# Technical Note 2: Highways

Project: Dobroyd Mill, Jackson Bridge / Hepworth,  
West Yorkshire

24 November 2017

This Technical Note has been written in response to the additional consultation comments dated 24<sup>th</sup> October 2017 made by Kirklees Metropolitan Council's (KMC) Highways Officers on planning application reference 2017 / 90620. The document was not annotated on every page but amounts to three pages. Reference is therefore made to the pages (1 to 3 in the PDF document). The said document is attached to this Technical Note.

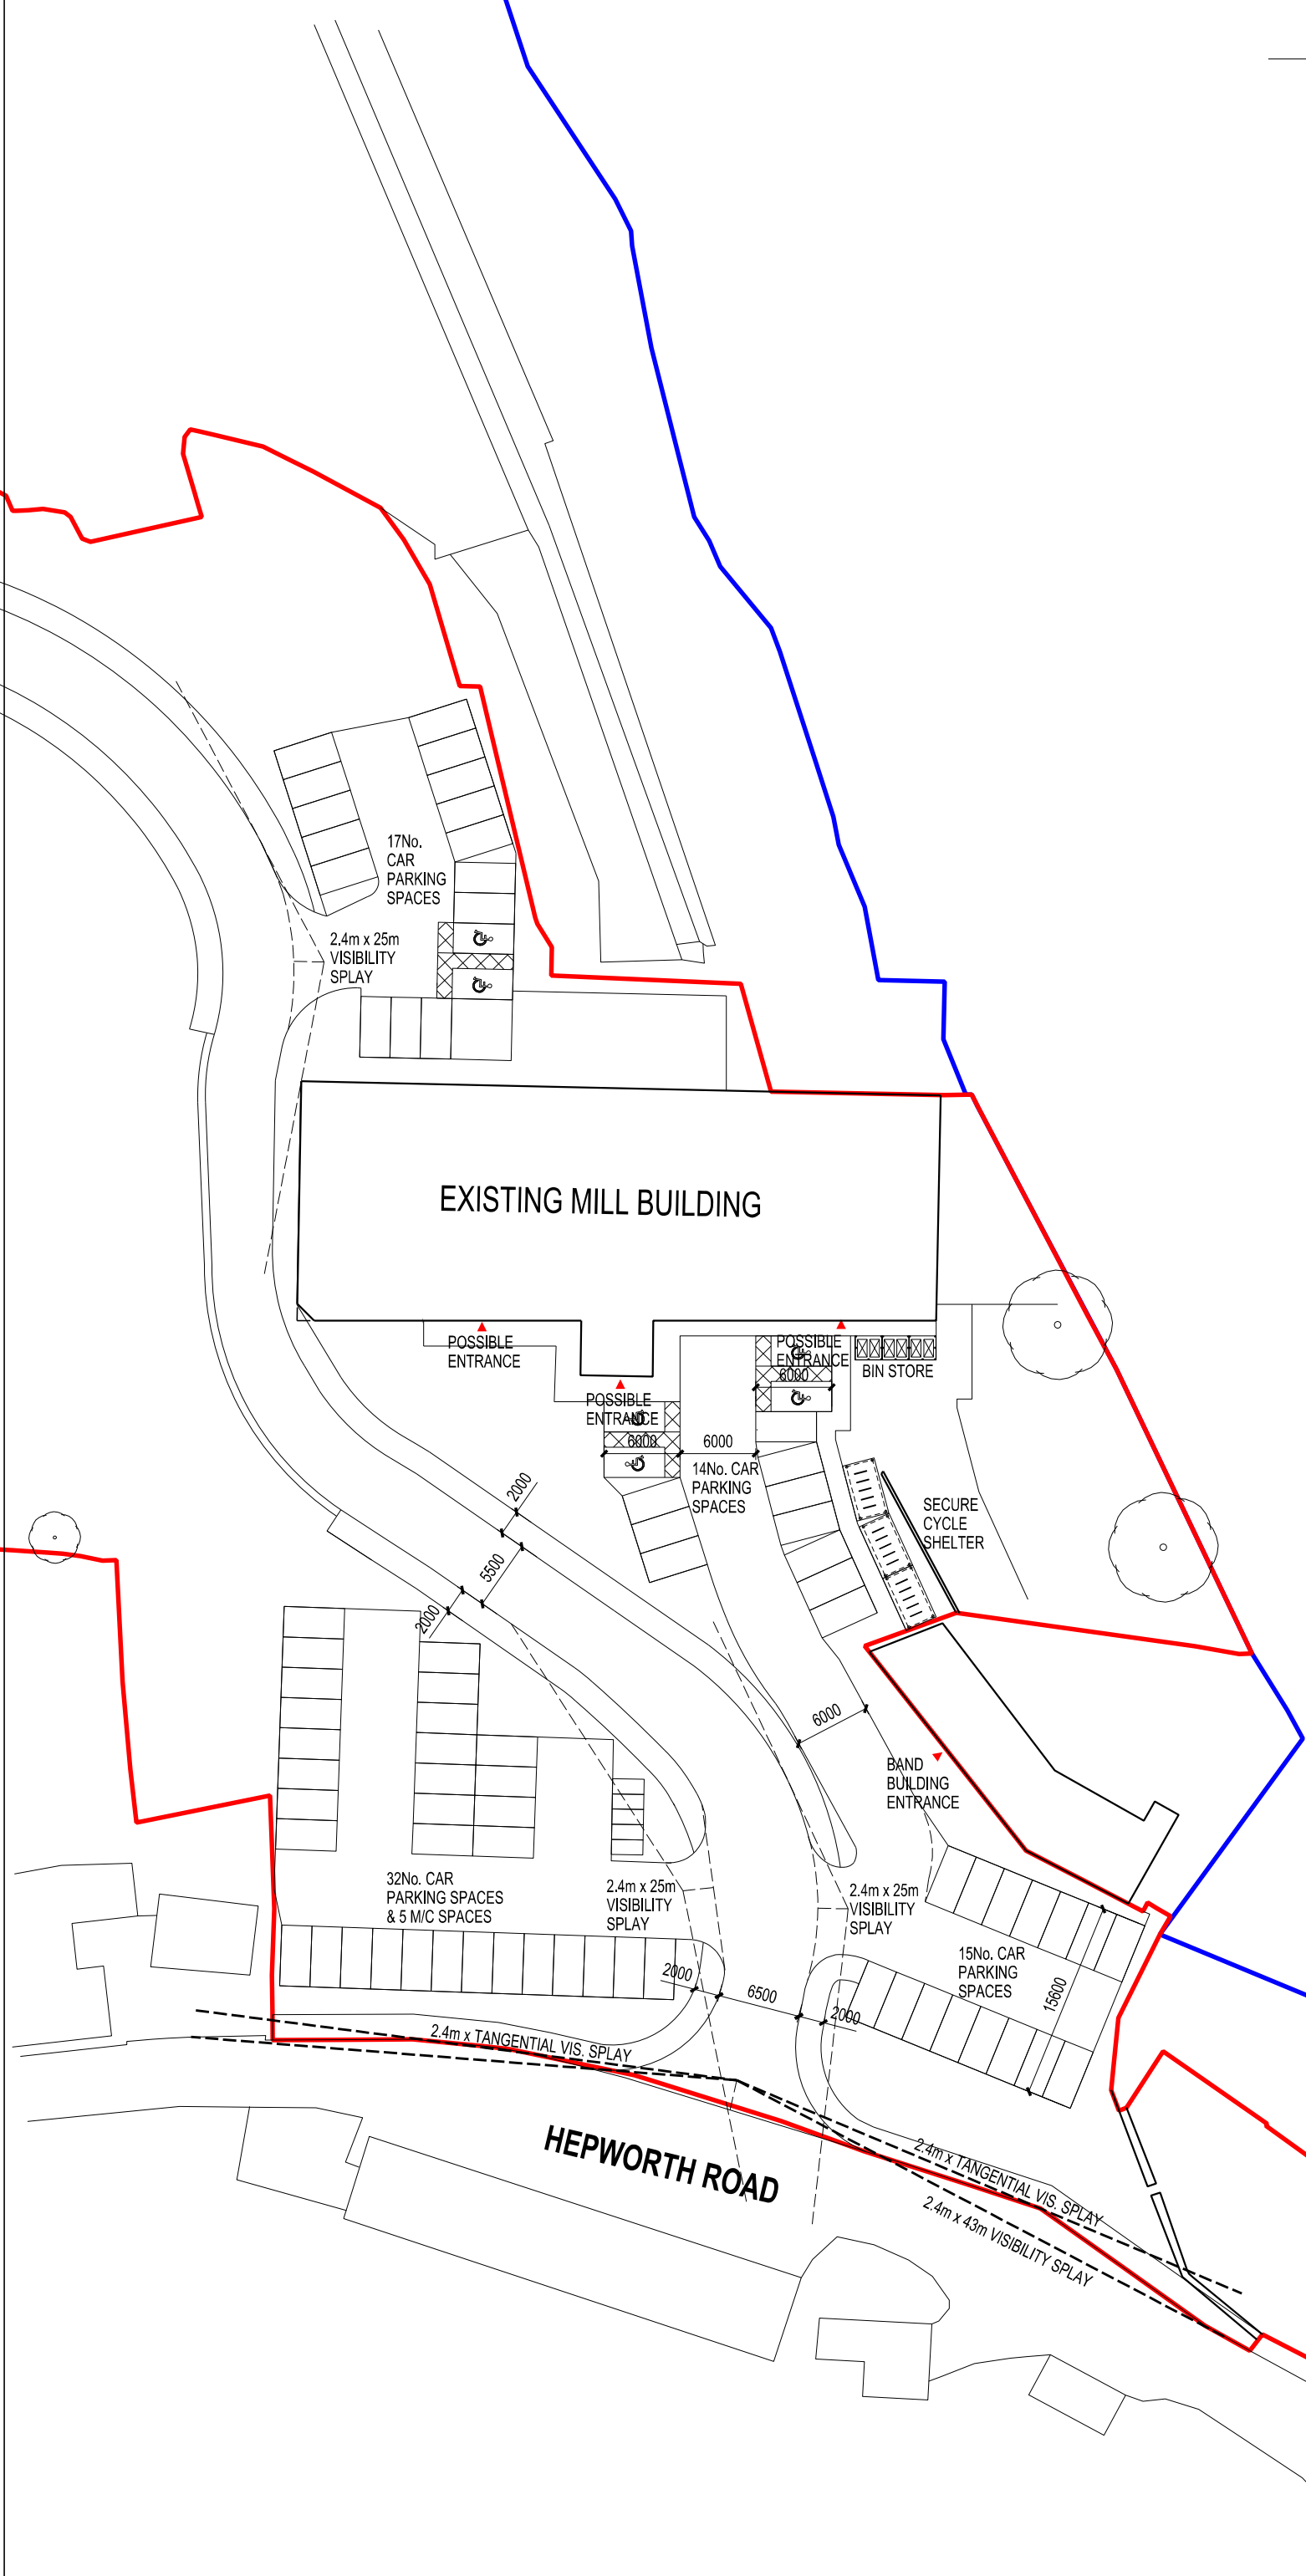
**Comment I** – a revised layout drawing has been prepared by KPP and is submitted.
